Our Ref: ID 2805
Your Ref: SSD-63475709

19 December 2024

Environmental Impact Assessment for Mingara Recreation Club Seniors Housing, Tumbi Umbi

Figure 9: Peak Flood Hazard – PMF Event (Pre-Development Scenario)

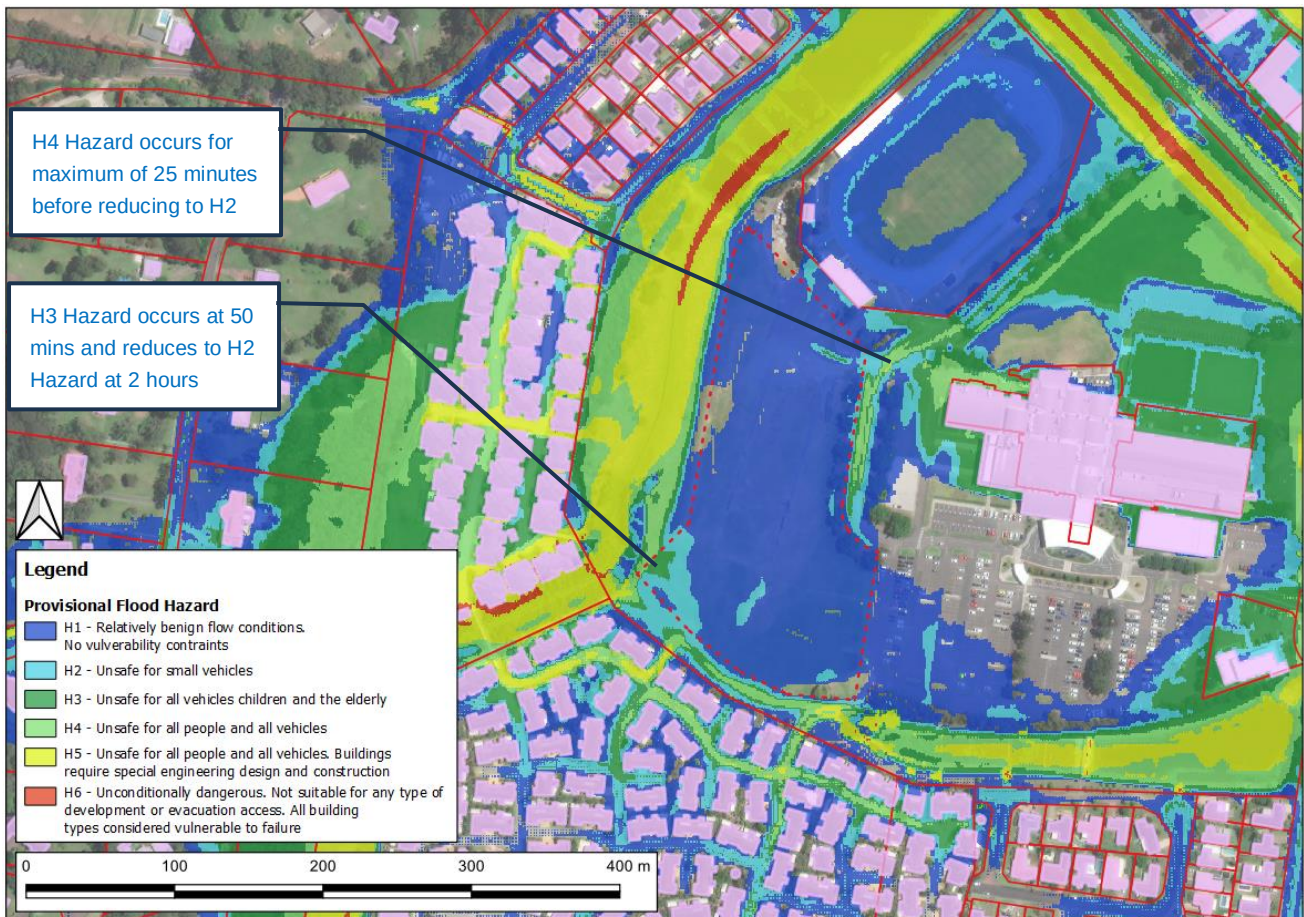
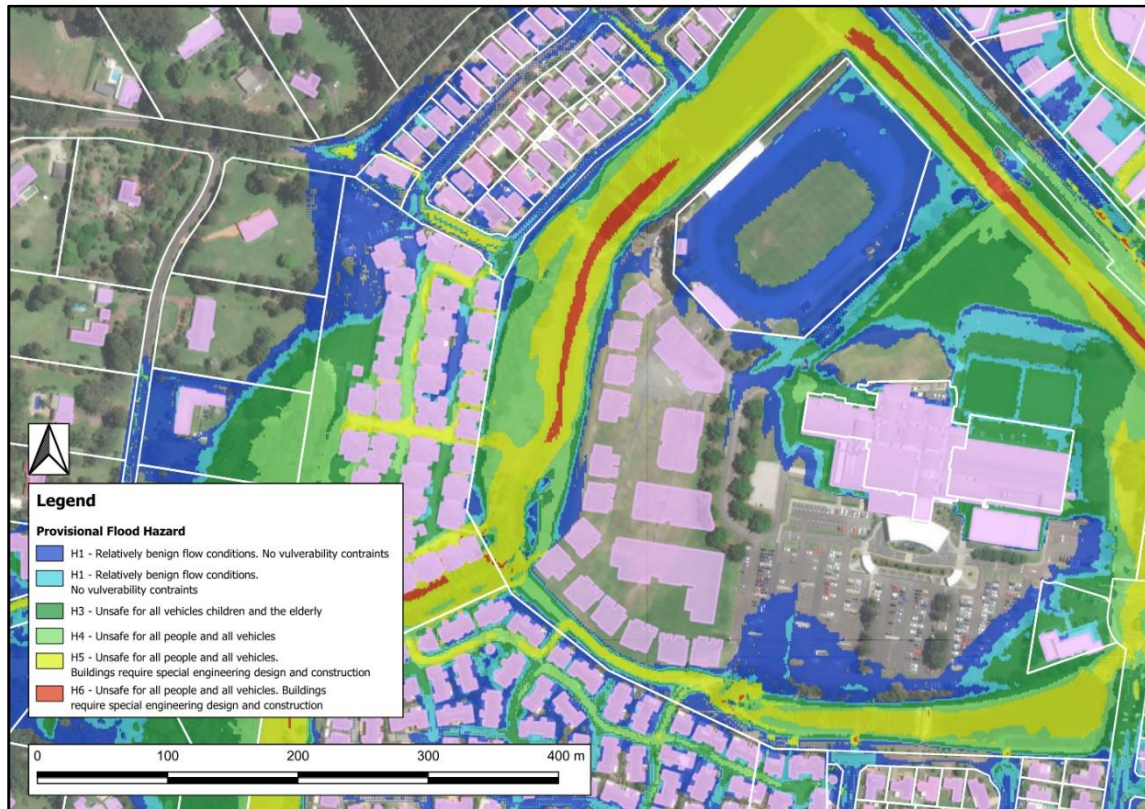
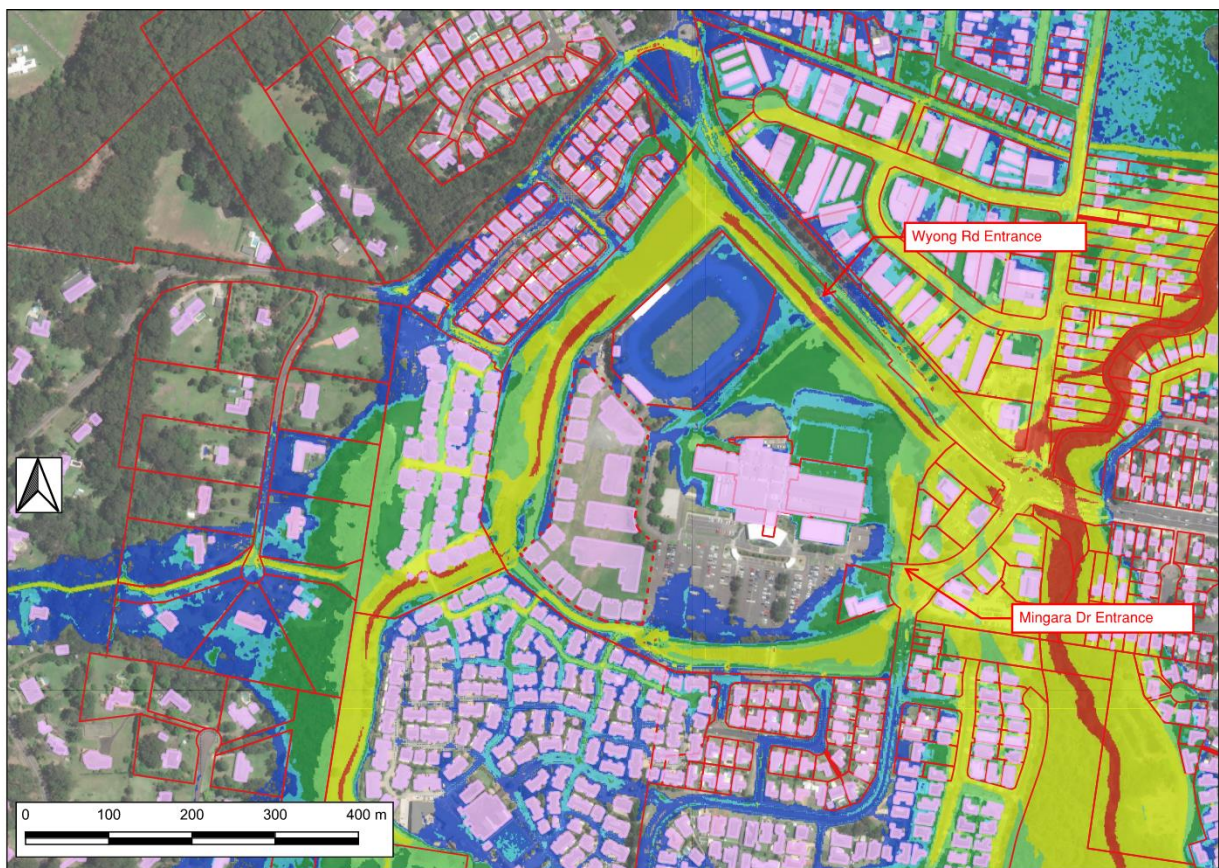
- **Recommend** that any access/egress constraints are addressed at the EIS stage. The site is surrounded by H5 hazard for up to 2 hours during a PMF⁴.

⁴ Stantec. 2024. Tumby Umbi Retirement Living Flood Emergency Management Plan (FEMP) Figures 9-11

Figure 12: Road Crossing Profile at Wyong Road

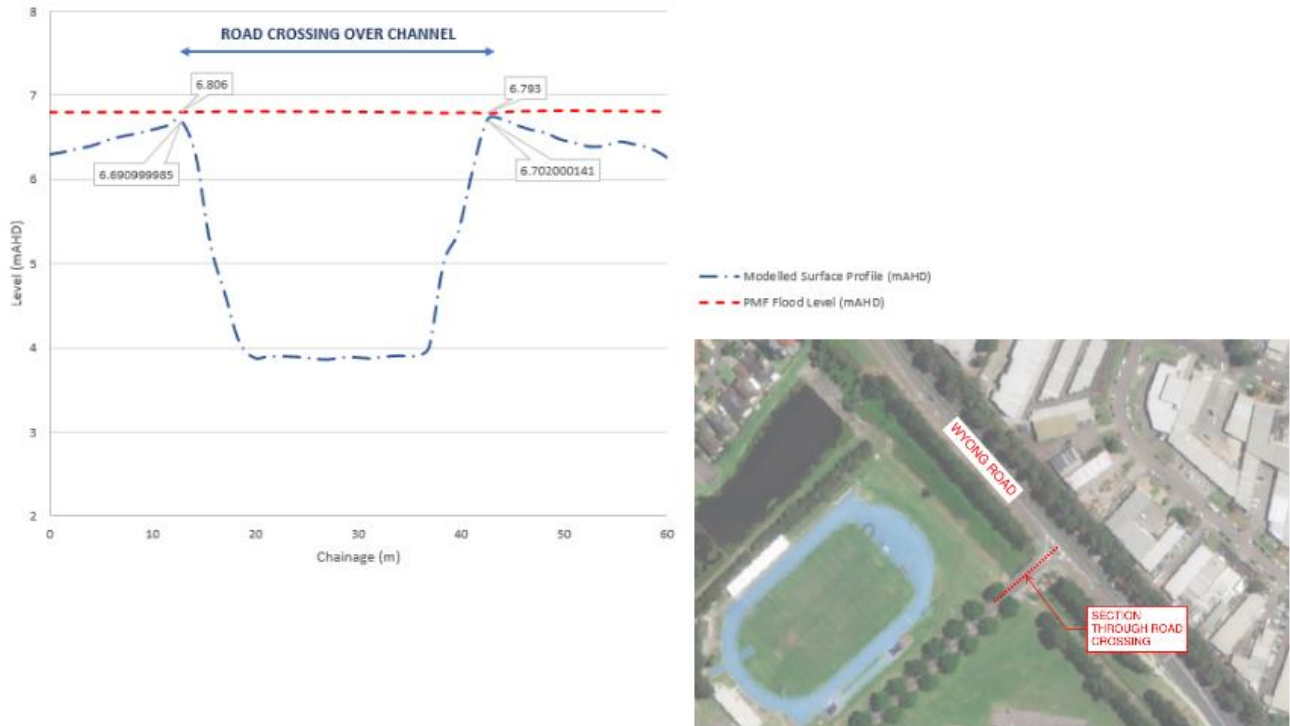
The Wyong Road entrance into the site is classified as a H5-H6 hazard in the PMF flood event. The maximum flood depth over the road in the PMF flood event is approximately 110mm with a duration of approximately 1 hour. Wyong Road is also subject to multiple road closures due to flooding.

Figure 13: Proposed Evacuation Route

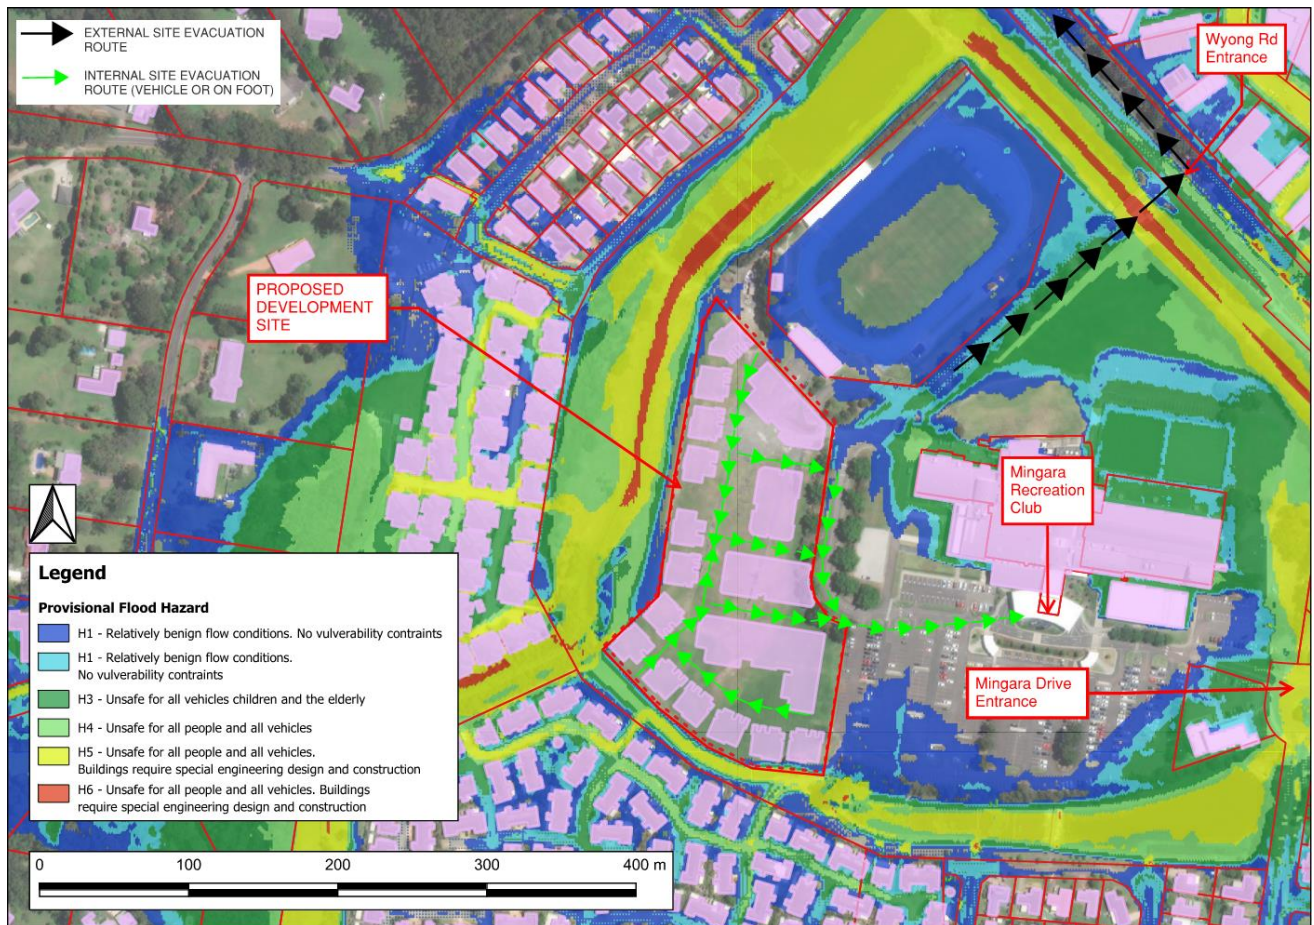
- **Recommend** that if the development proceeds, that the site design permits for flood free rising road access for the entire development due to the frequent flooding in the Tumby Umbi Creek catchment and limited to no warning time available³. NSW SES does not support strategies that rely on people entering floodwater.

- All references to driving or walking through floodwater should be removed.
